Our Ref: AB/124/11/A
Your Ref:

The Town and Country Planning Act 1990 (as amended)
The Town and Country Planning (Control of Advertisements) Regulations 2007 Town
and Country Planning Development Management Procedure Order 2010 (as amended)
Erect 1No. non-illuminated hoarding sign at the site entrance. This application lies within
the South Downs National Park Authority.
Arundel Cricket Club Waterwoods Plain Chichester Road Arundel

Proposed Hoarding

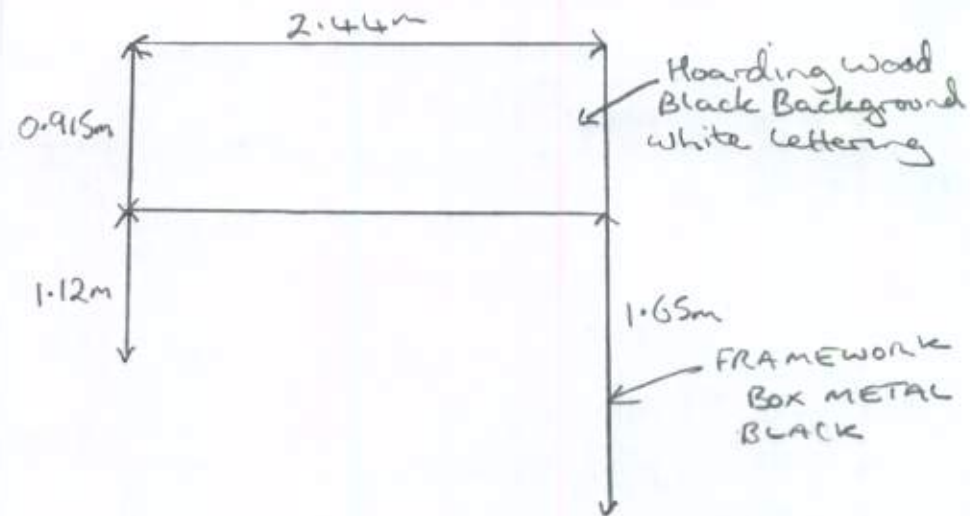
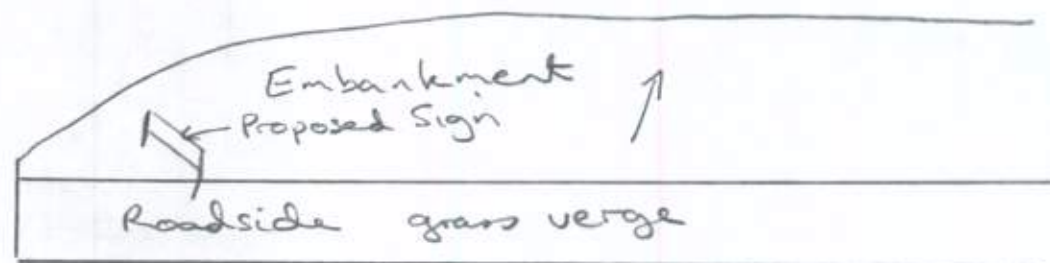
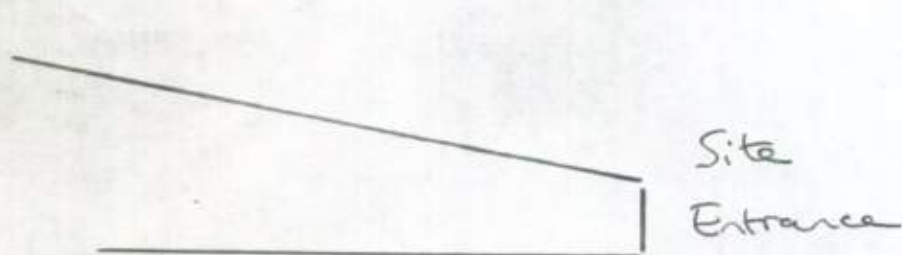
Please submit 2 copies or 1 electronic copy of amended plans of the proposed sign to include the lettering.

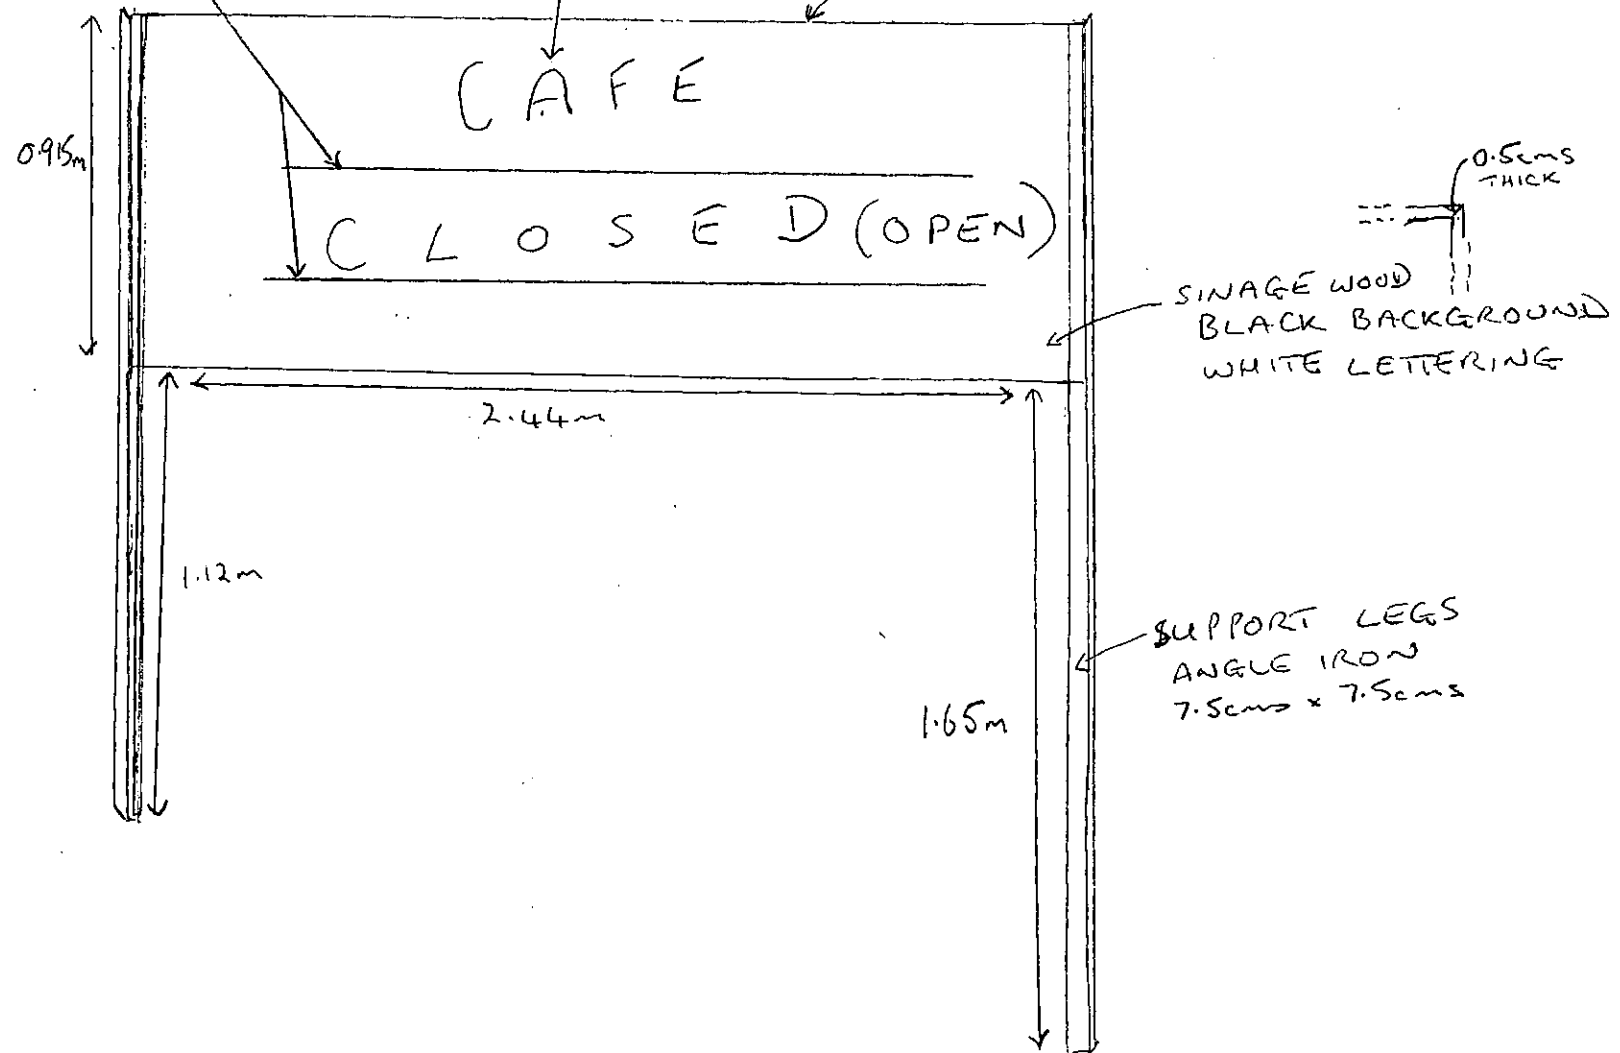
Please clarify if the exit sign referred to in your accompanying letter, forms part of this application. If yes, please submit plans accordingly.
